**Our Case Number:** ACP-323849-25

**An  
Coimisiún  
Pleanála**

**Re:** The proposed development is for a mixed use development that seeks the regeneration and adaptive reuse of a strategic brownfield site, as part of the Limerick City and County Council 'World Class Waterfront revitalisation and transformation project' 'Cleaves Riverside Quarter' in the townland of Farranshone More in Limerick City.

An Observation on Cleeves Riverside Quarter, Limerick.

Job/Drawing No
CRQMP-FCBS-06-00-DR-AA-0250 P01
Cleeves Limerick
FLAXMILL-Proposed GA Plan Level 00-01

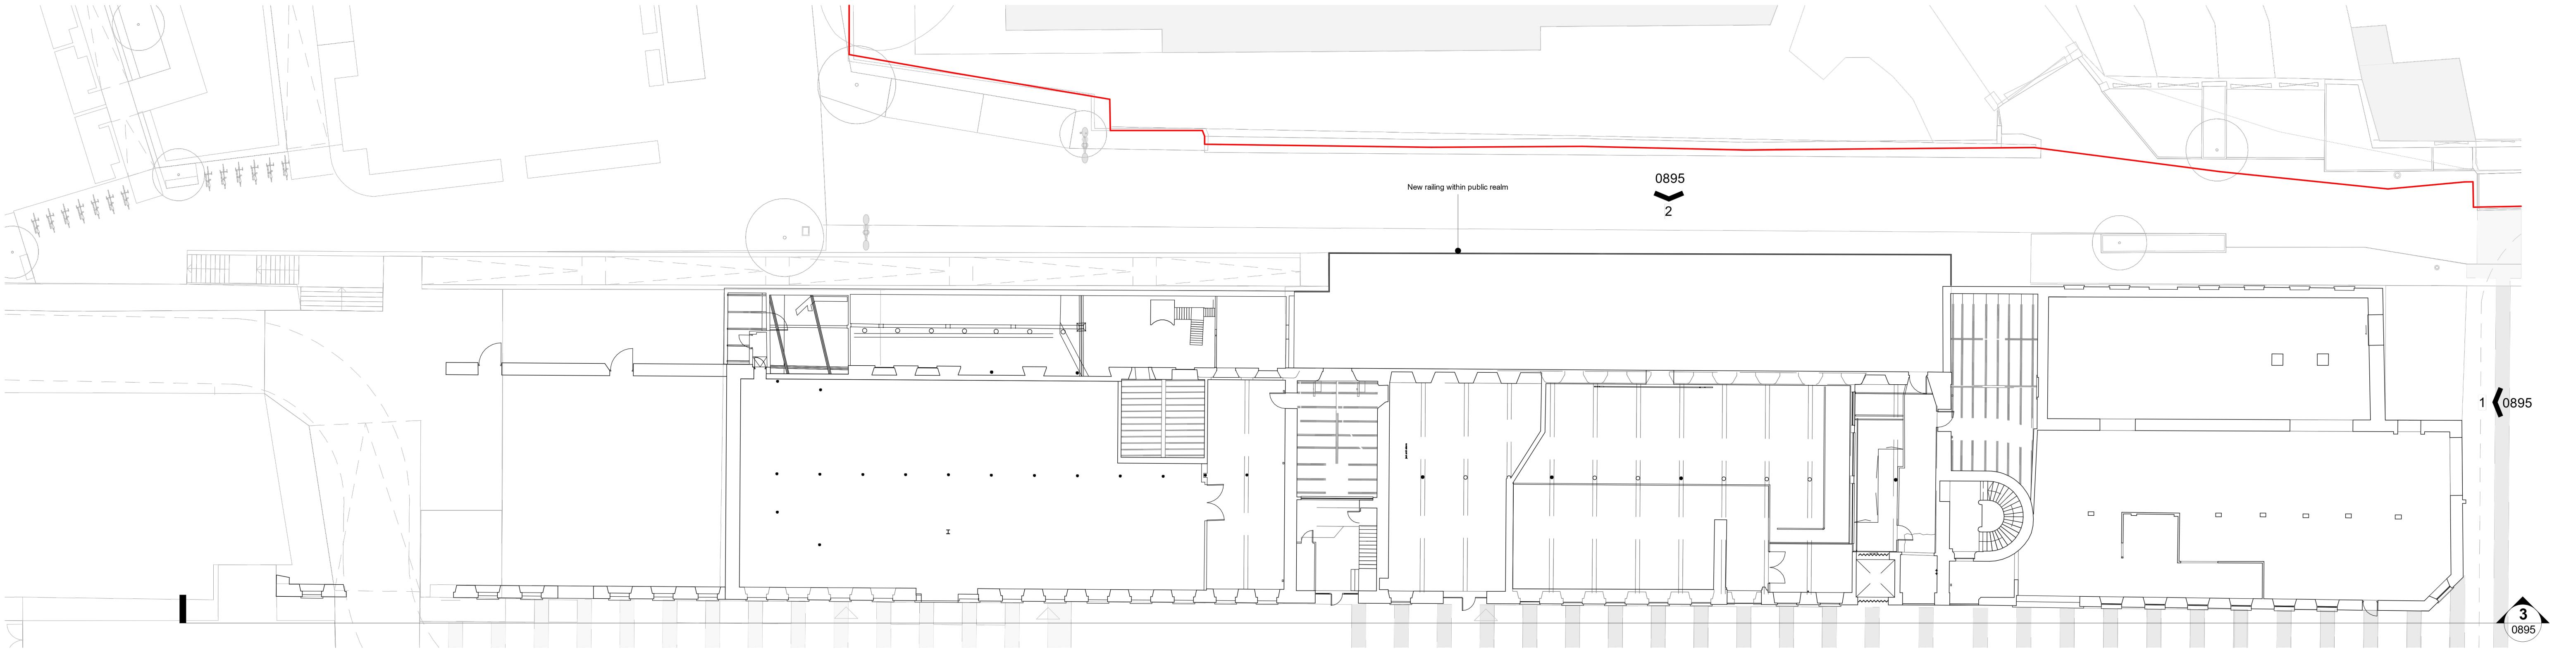
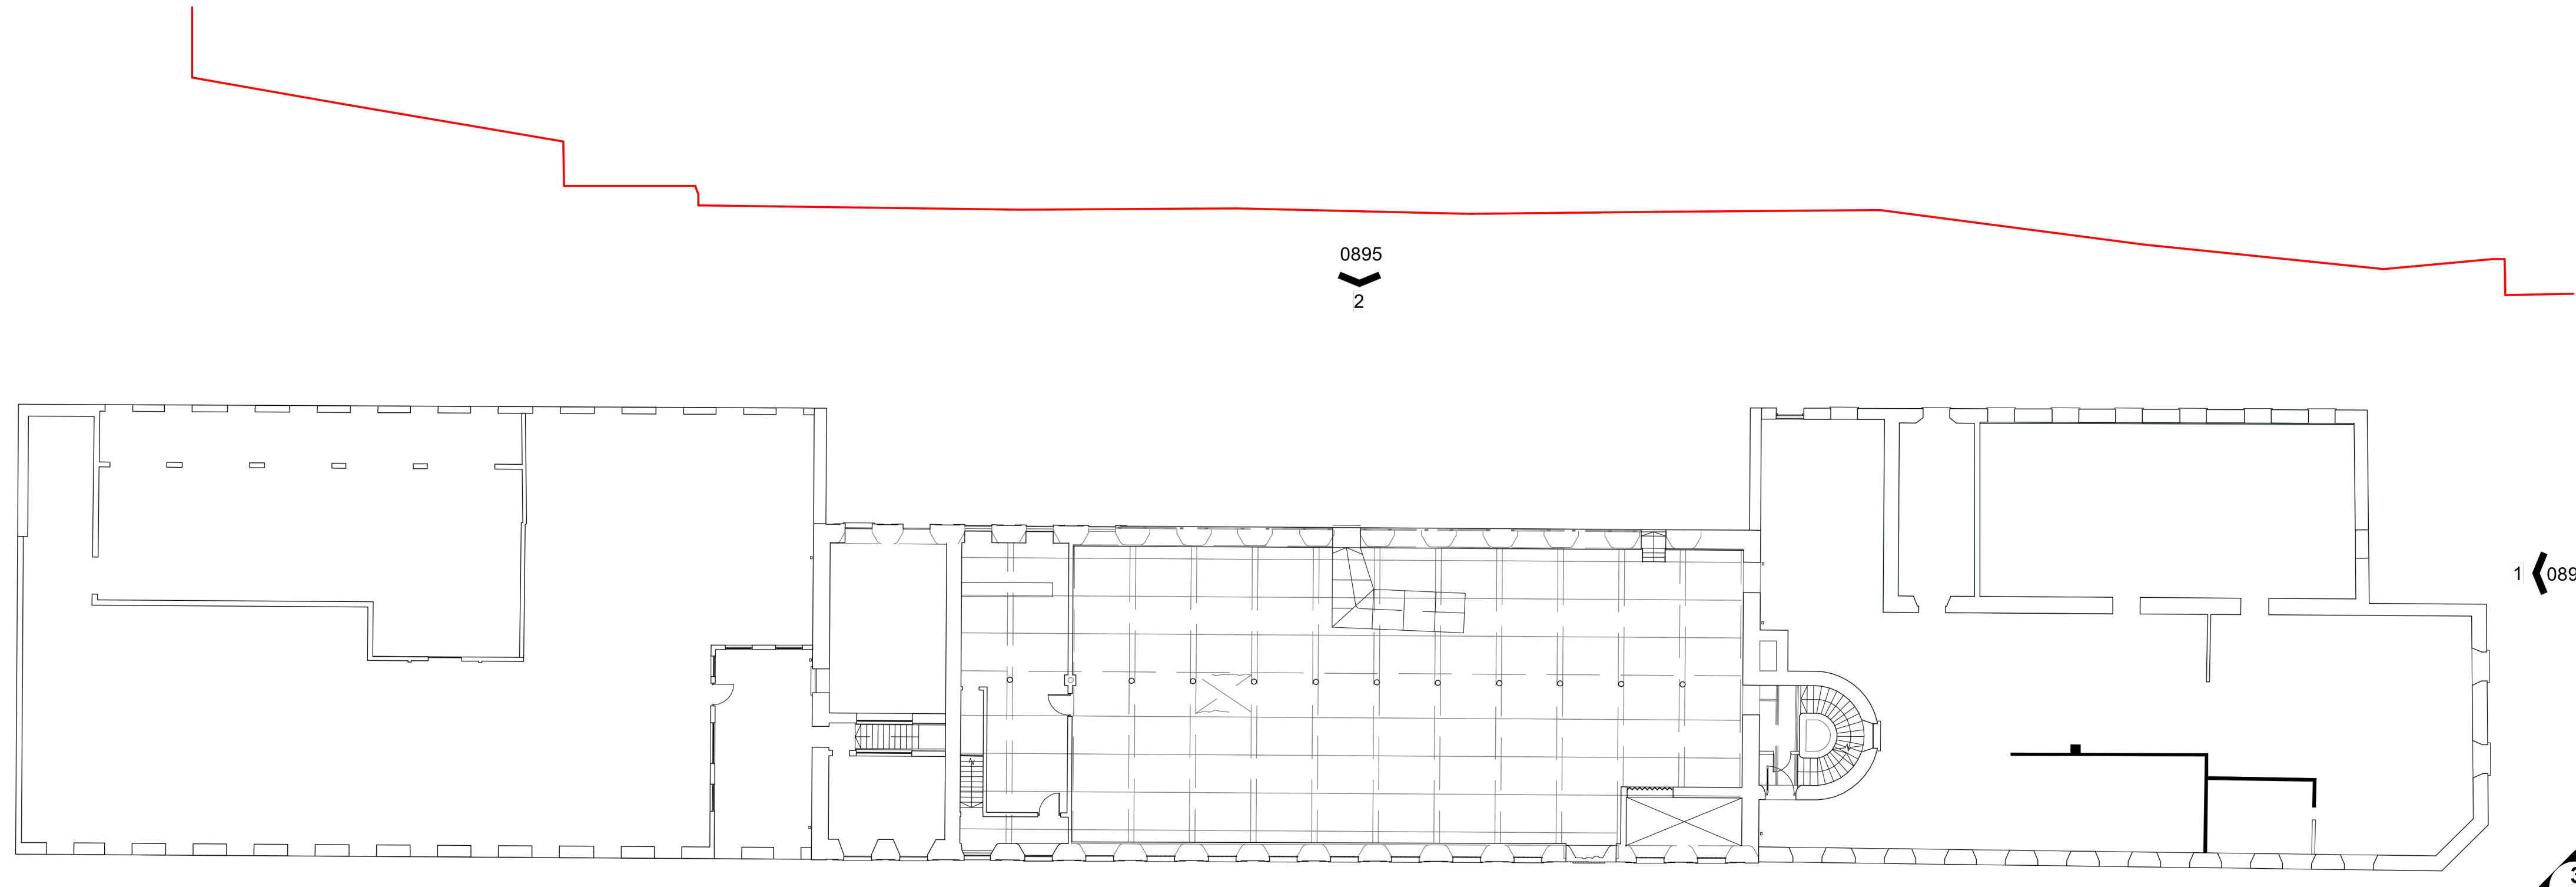
Unfortunately, this is its only record of the fern on the site, and from this it appears that the site was not thoroughly examined. On a site visit on 16<sup>th</sup> June 2022 by members of the Limerick IWT it was also observed growing on the south-facing wall of the flaxmill building, in the joints between the blocks (see attached photo). There were numerous colonies of the plant. In addition it was noted to be present on the internal side of the O'Callaghan Strand wall.

As no observations of the Maidenhair Fern on the flaxmill wall has been presented in the EIAR it follows that no mitigation measures have been proposed.

drawing	Riverside Ground Floor Plan- Existing/To Be Demolished				
drawing no.	CRQMP-BMEA-6X-00-DR-AA-1980				
project	scale	1:200 @ A1	drawn	TS	project no.
Cleeves Riverside Quarter Masterplan	date	Oct. 2025	checked	KH	CRQMP
client	Limerick Twenty Thirty				
	revision	P01

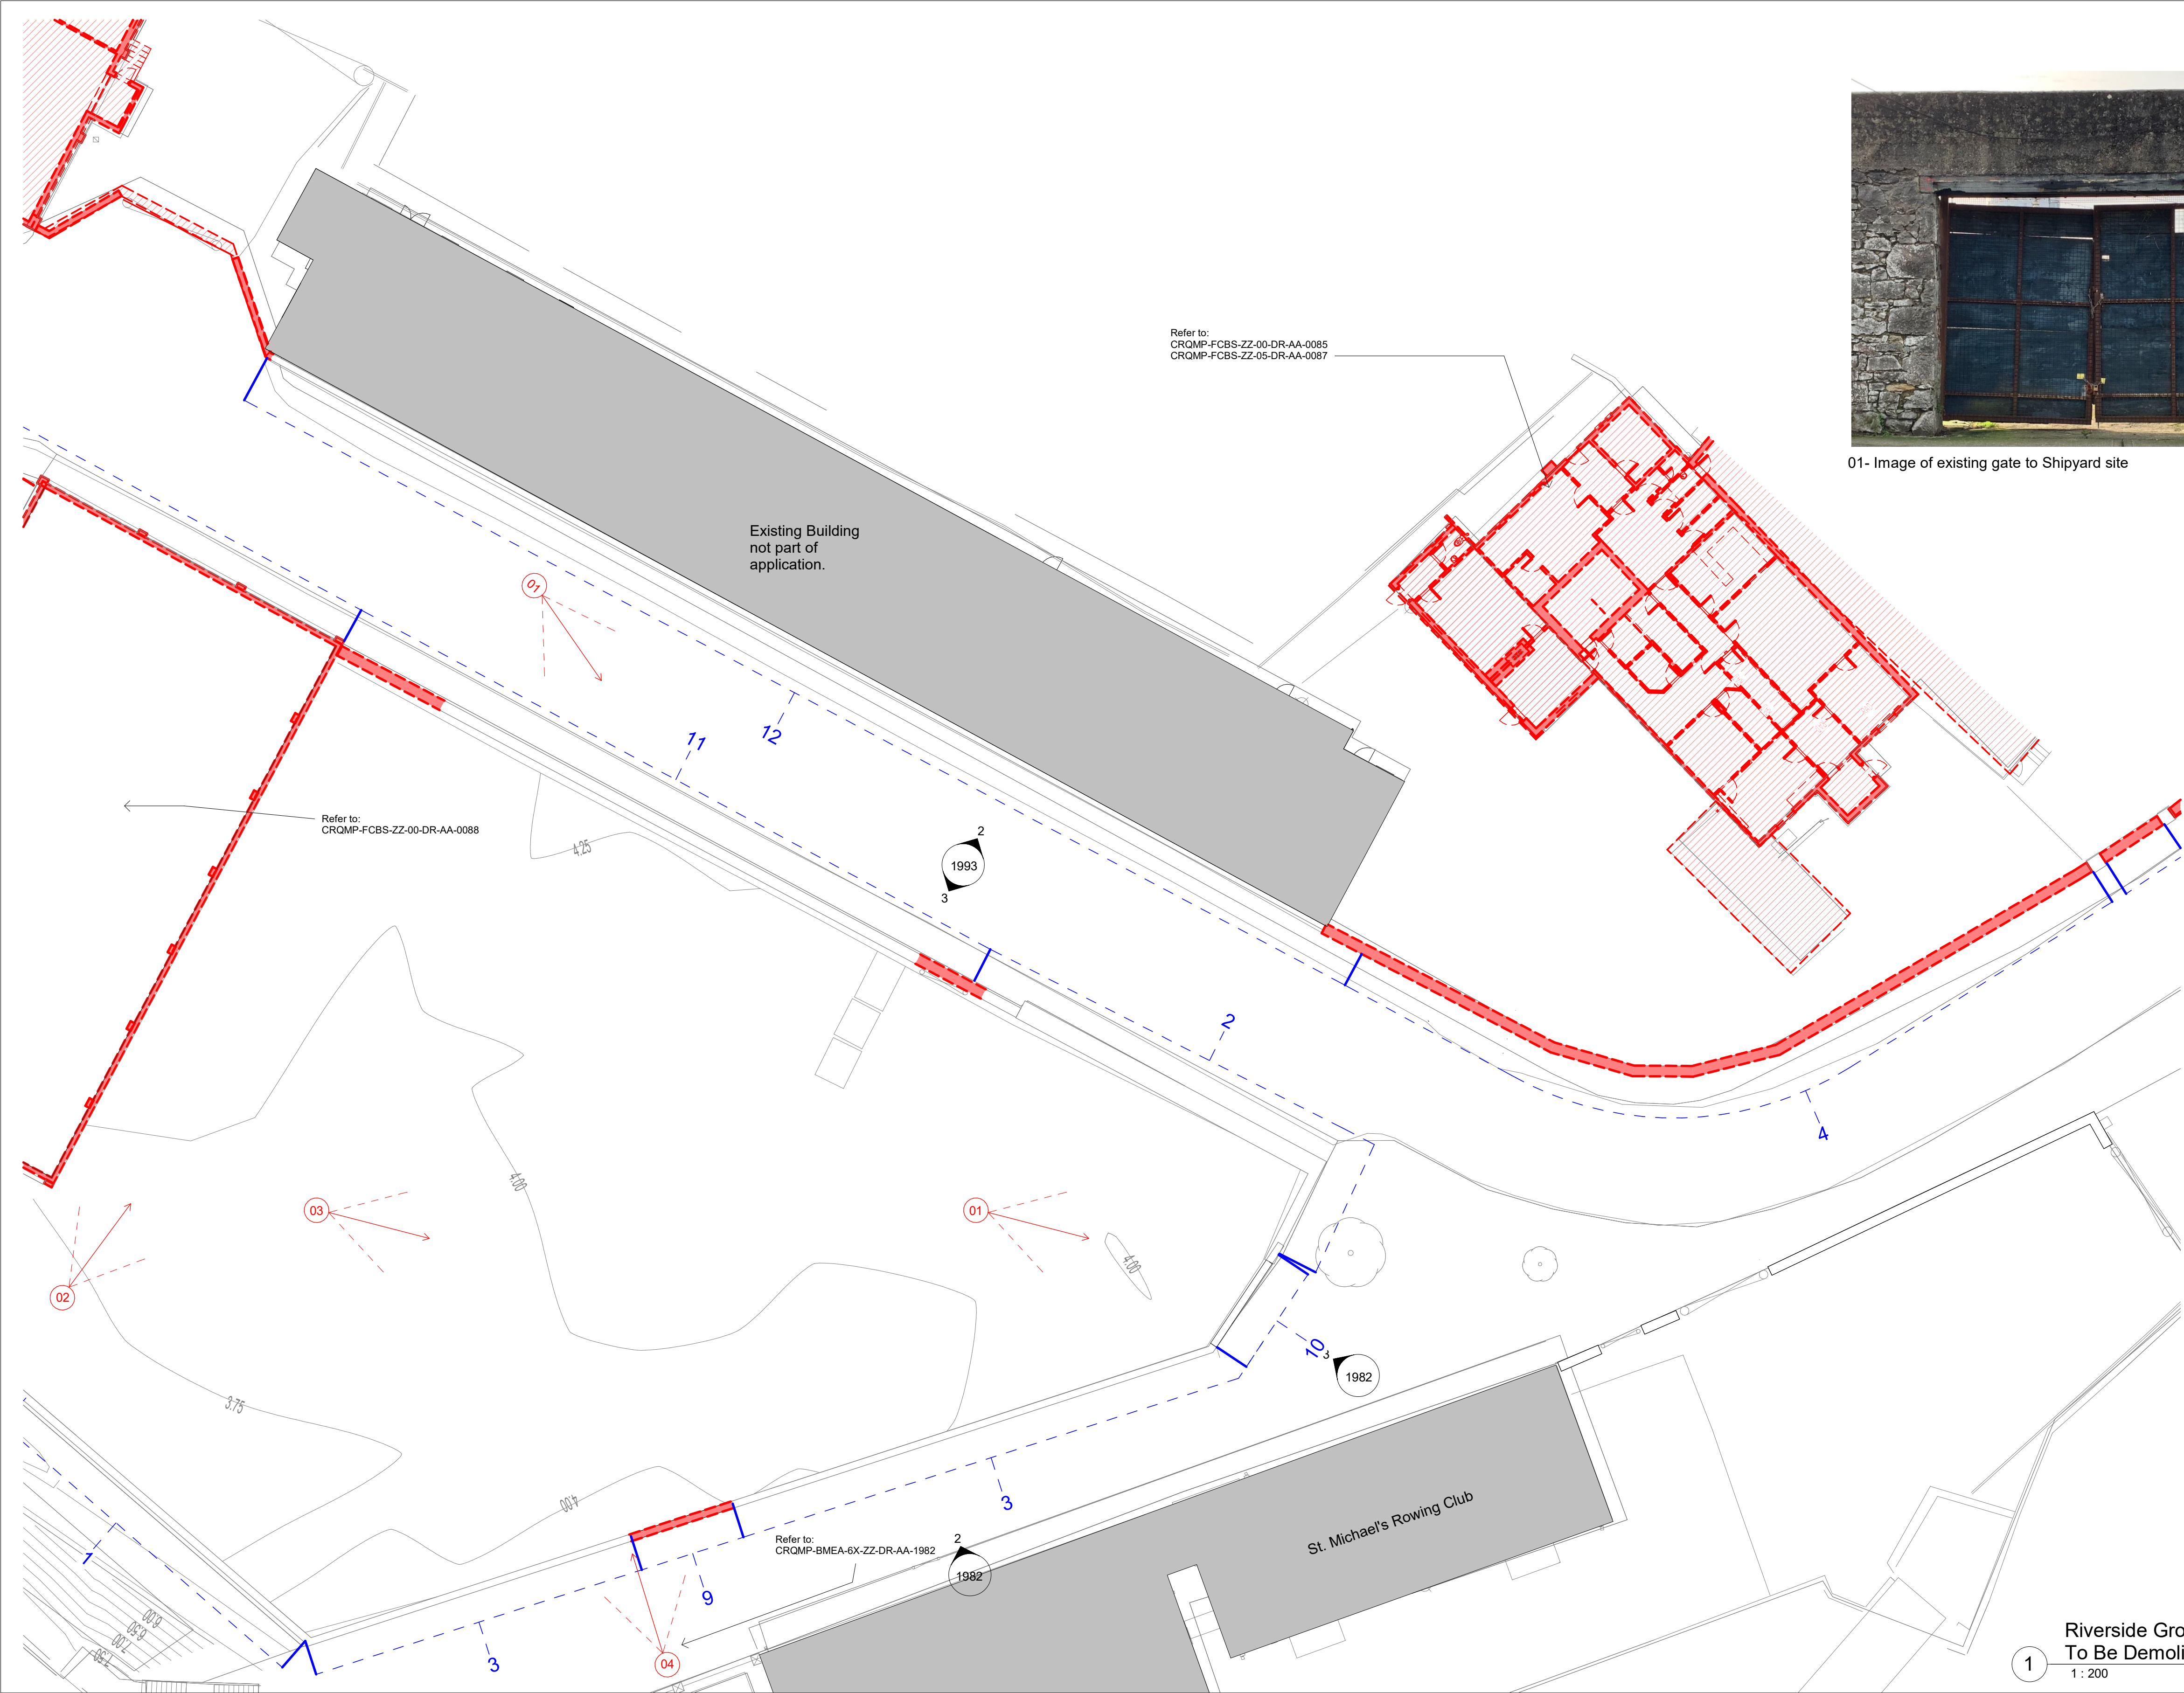
The development proposes to lower the boundary wall on O'Callaghan Strand to 450mm, and this will seriously deplete, if not entirely remove, the Maidenhair Fern from the O'Callaghan Strand wall. It is also proposed to stabilise the walls on the North Circular Road, following works to facilitate raising the level of the road.

We would recommend that these old walls should not be repointed (unless absolutely necessary for safety reasons) to avoid removing any of the plants which have naturally colonised them.
